HYDROLOGY SECTION PROJ. NO. 4-17 DATE: 2/29/84

CONFERENCE RECAP

SUBJECT: Olwell Luba Center

RE: GRADING & DRAINAGE PLAN FOR OILWELL LUBE CENTER
(J17-D7) RECEIVED APRIL 5, 1984

DRAINAGE & GRADING PLAN

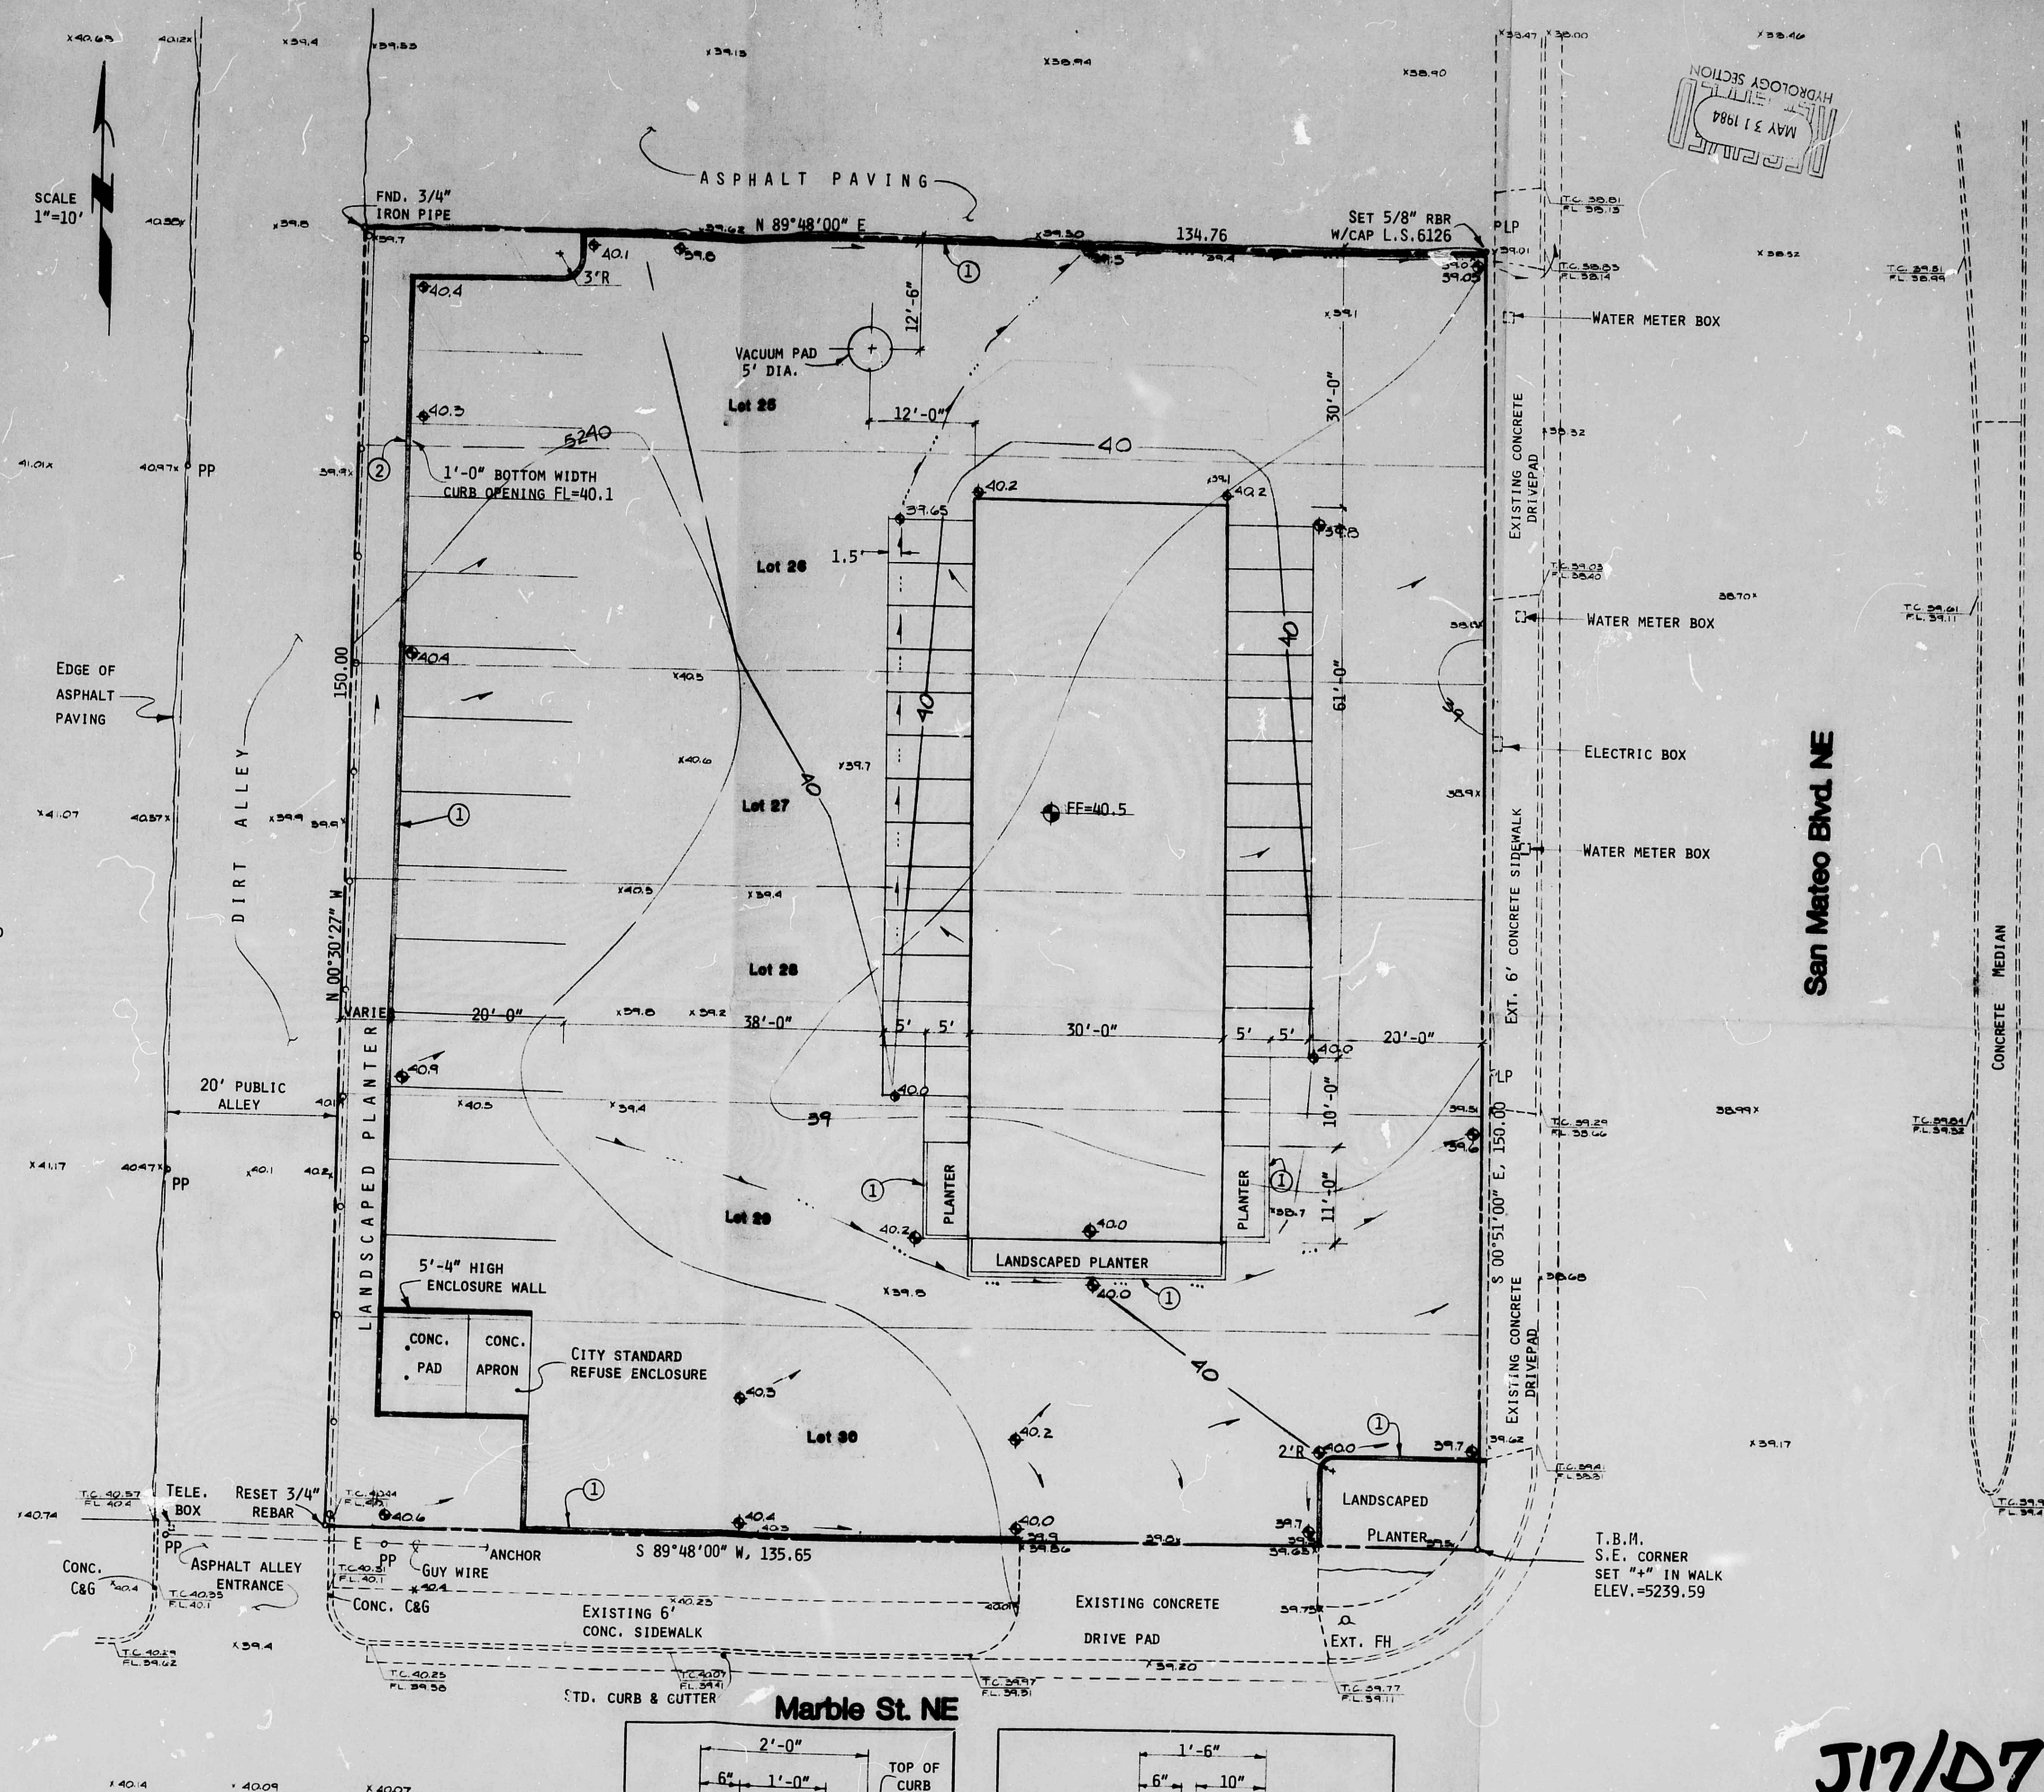
FINDINGS: ① Drainage Plan per DPM required
② Lotlines shall be removed by platting
or a drainage covenant should be provided
for drainage across the lotlines.
③ Existing impervious area to be
modified. Maintain existing runoff ^{rate}
reduce if feasible by addition of landscaping.

The above referenced plan, dated April 5, 1984 is approved. However, prior to issuance of the building permit a copy of the recorded plat removing the lotlines, or a recorded drainage covenant for each lot will need to be provided for our files.
